**Consultation Response from: KC Environmental Health (Pollution & Noise Control)**

**2023/93082 - Land Adjacent, 60, Northgate, Cleckheaton, BD19 3NB**

**Discharge of conditions 3-13, 22, 23 and 25 of previous permission 2022/91730 for demolition of former dairy/snooker centre/storage and erection of 9 light industrial units**

**Responding Ref:**  
**WK/202334800**

Figure 1 – Site Location with background locations

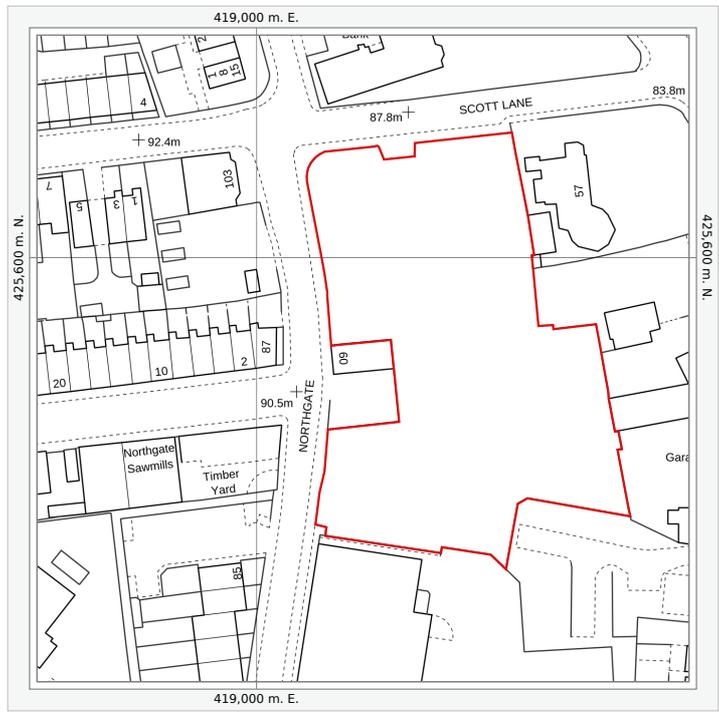
The applicant has submitted a Noise Impact Assessment authored by Clover Acoustics, dated 12 October 2023 Ref 4824-R1. A background noise survey was conducted on Thursday the 6<sup>th</sup> of April 2023 from two measurement positions (MPs) as shown in figure 1 and a summary of the findings is shown in tables 1a and 1b (MP1) and 2a and 2b (MP2). The nearest sensitive receivers (NSRs) have been identified as the neighbouring residential dwellings on Northgate to the west of site and Scott Lane to the north.

The report considers the operational noise within the units but does not make any reference to vehicle noise with the Design & Access statement stating the access to the site is via Scott Lane, opposite NSR1 which may impact on the predicted levels and the BS4142 assessment. The submitted report is therefore rejected and we will require this additional information before considering the discharge of this condition.

We recommend this condition is not discharged until the additional information is received and accepted.

Figure 4 – Recommended Wall Upgrade

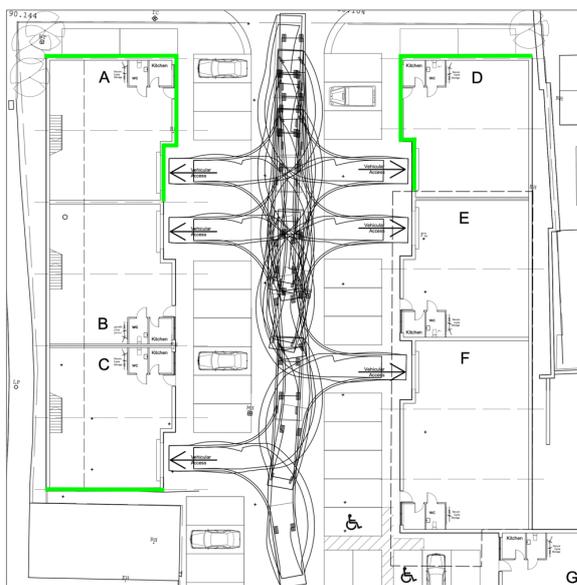
A recommendation is made for some of the building fabric construction to Units A, C & D to be upgraded as shown in figure 4. Noise modelling was conducted with the roller shutter doors
